Stage 3 Facilities, Sydney Business Park **Response to Submissions**

November 2020

PJEP Ref: SBP Stage 3 Facilities_RTS_Nov20

# Staff Amenity Zones (Warehouse 1 - Level 2)

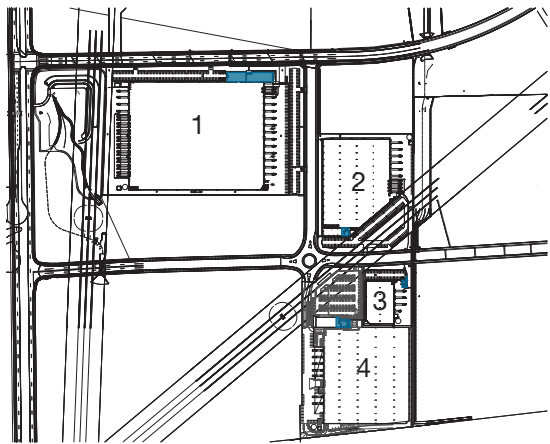
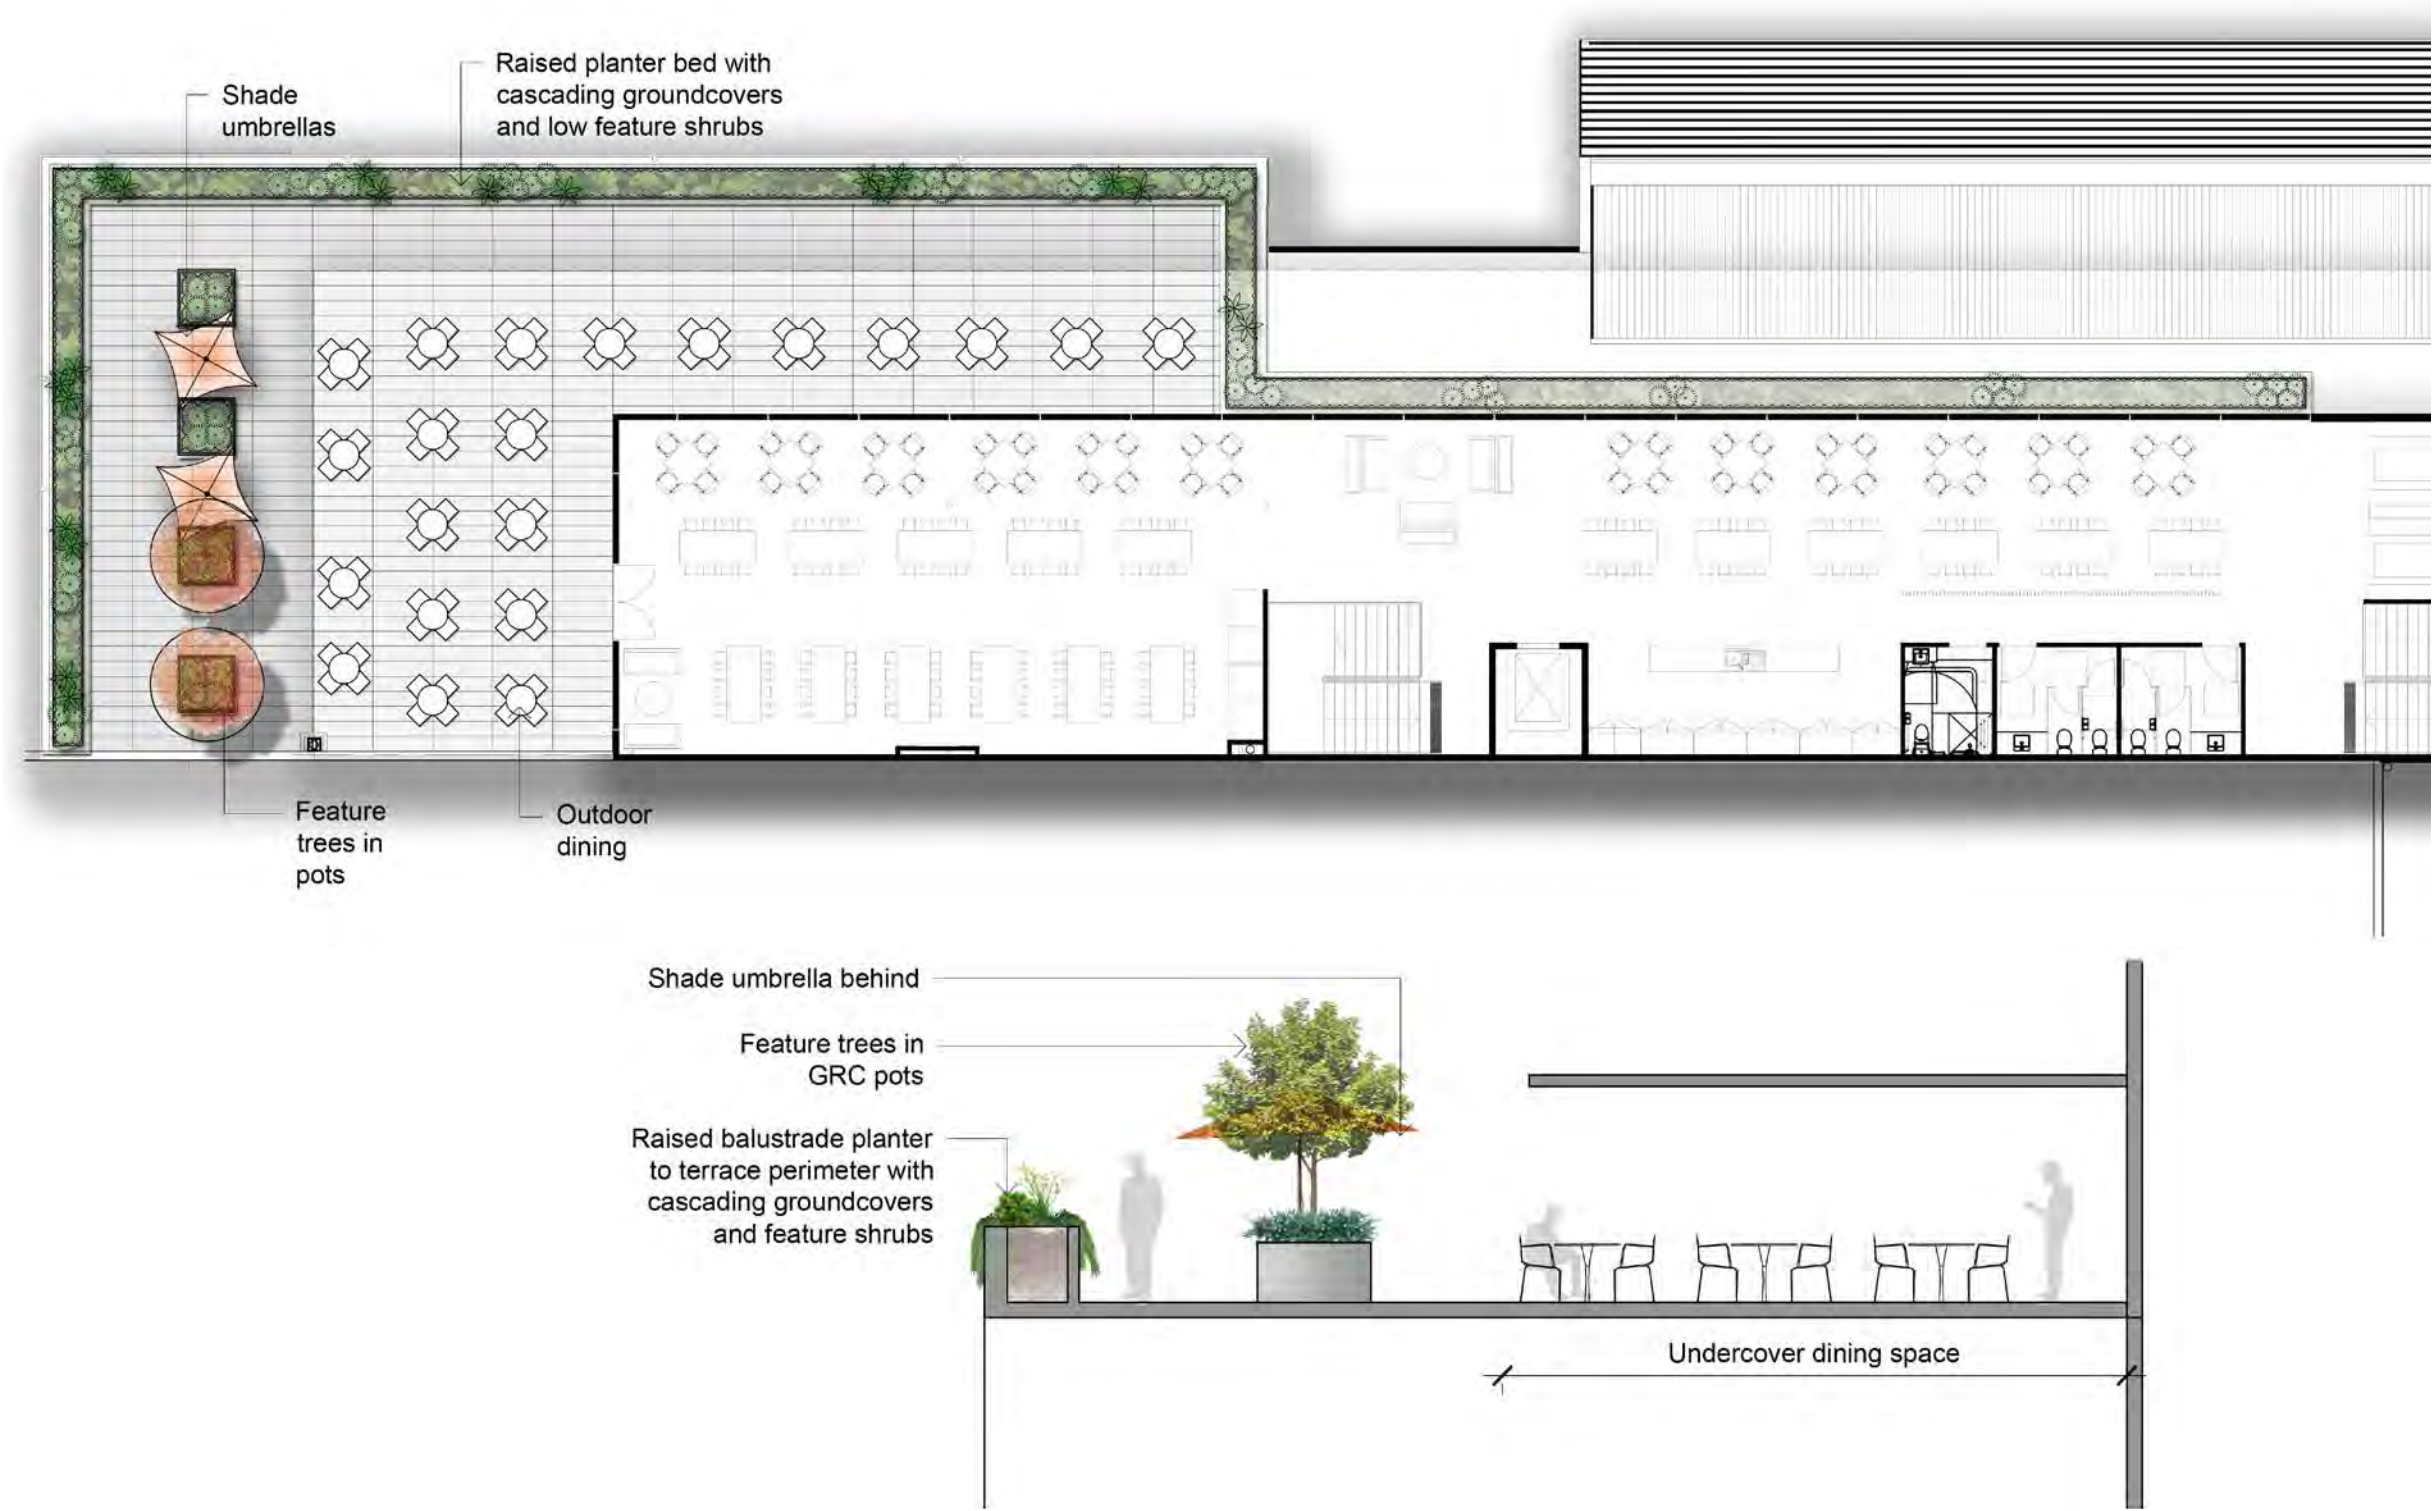
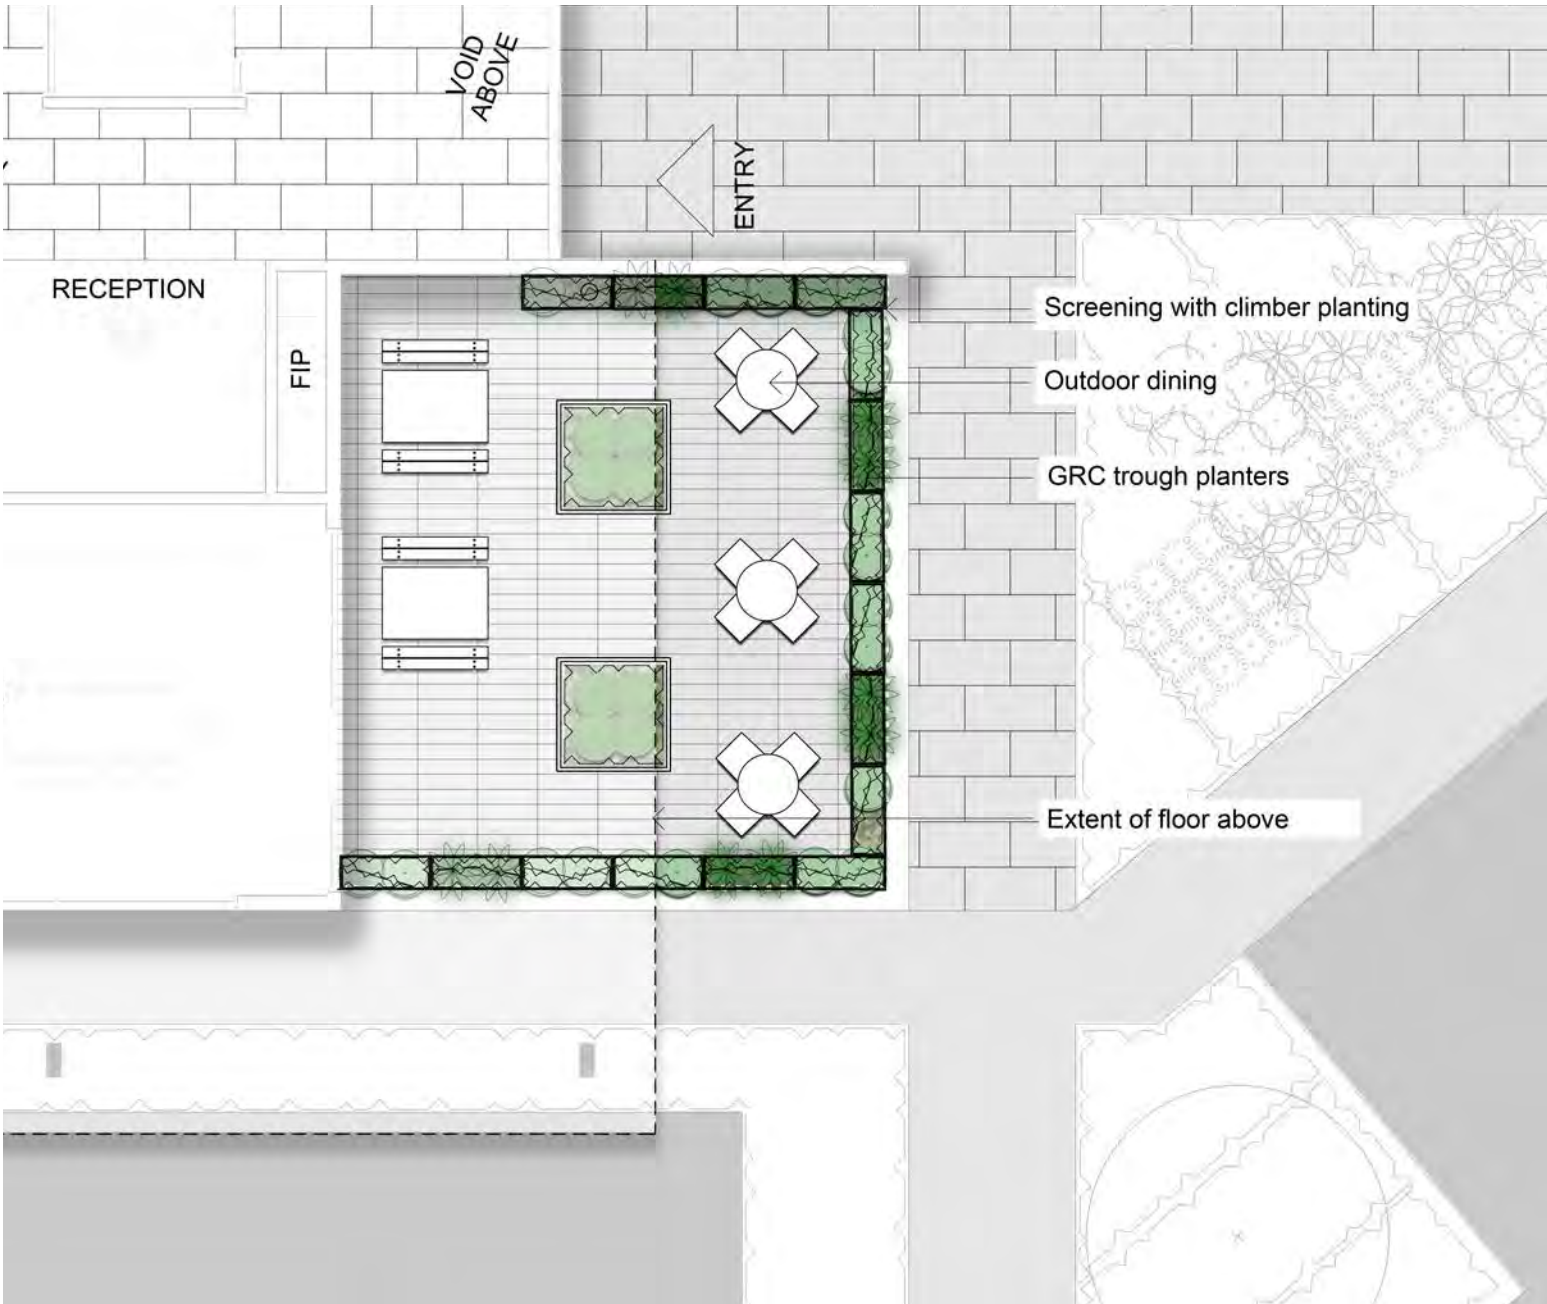
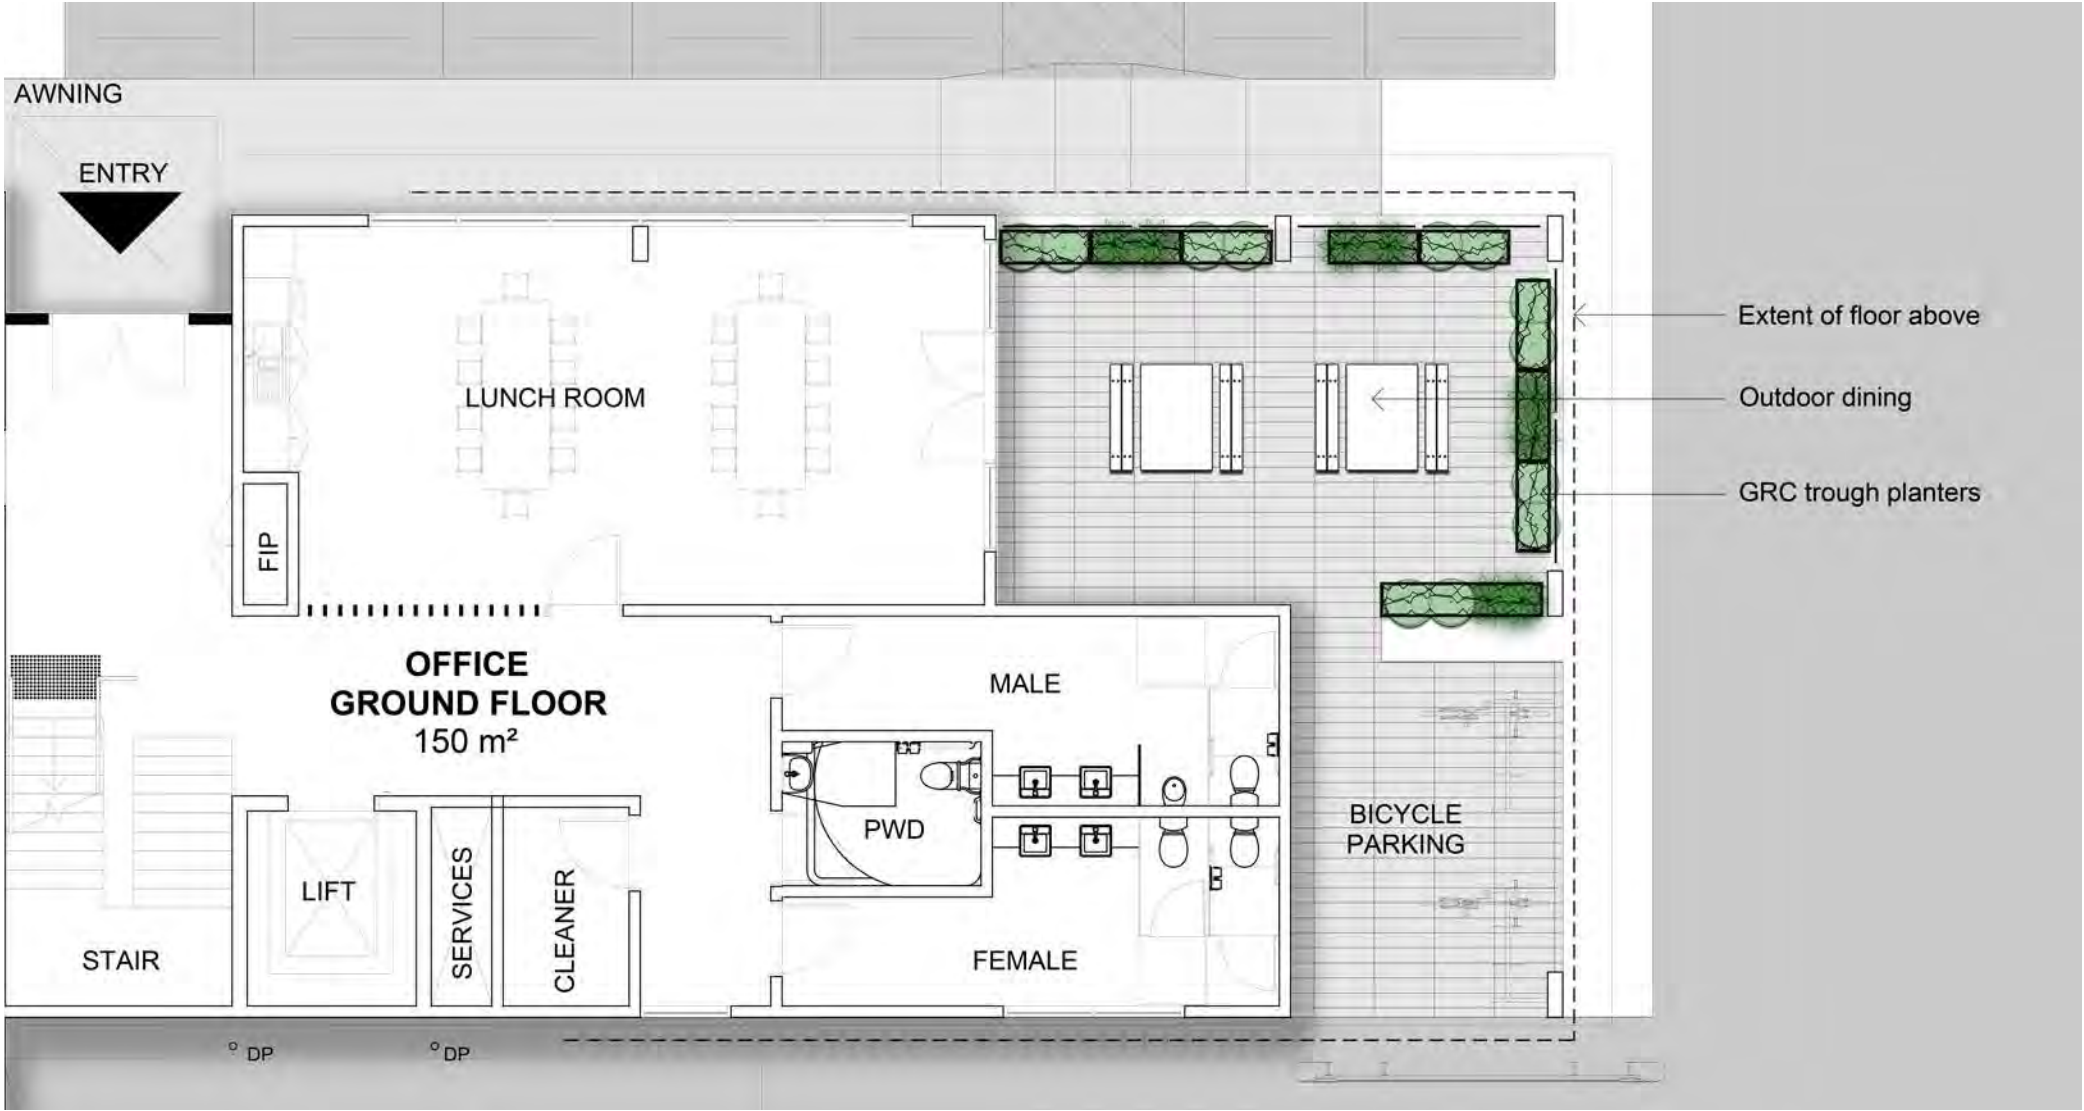
Aspect	Issue/Recommendation	Response
		with the adjacent indoor lunch room, the total communal area comprises some 349 m ² , or 0.8% of the site area.
	Details of landscaped communal areas for Warehouses 2 and 3 have not been provided as part of landscape plan	The amended landscape plans include details of the outdoor staff communal areas for Warehouses 2 and 3 (see Appendix B).
<i>e. Setbacks</i>	All warehouse carparks encroach on the 7.5m setback. Hardstand areas not permitted in setback	<p>As shown on the architectural plans, only minor areas of carpark and driveways encroach into the 7.5 metre setbacks for each of the warehouses, with the minor encroachments due to the orientation of the roads and lots.</p> <p>However, the average setback for each of the facilities comfortably complies with the DCP standard. This averaging approach has been adopted for a number of approved developments in Sydney Business Park, for example the Bucher Municipal Facility (DA 18-02532) and the ASICS Facility (SSD 9153).</p> <p>Given this, and that full compliance with the DCP standard would necessitate significant compromises to the developable area of the sites, and that the proposal provides for high quality landscaping of the street frontages, the minor encroachments are not considered to be significant.</p>
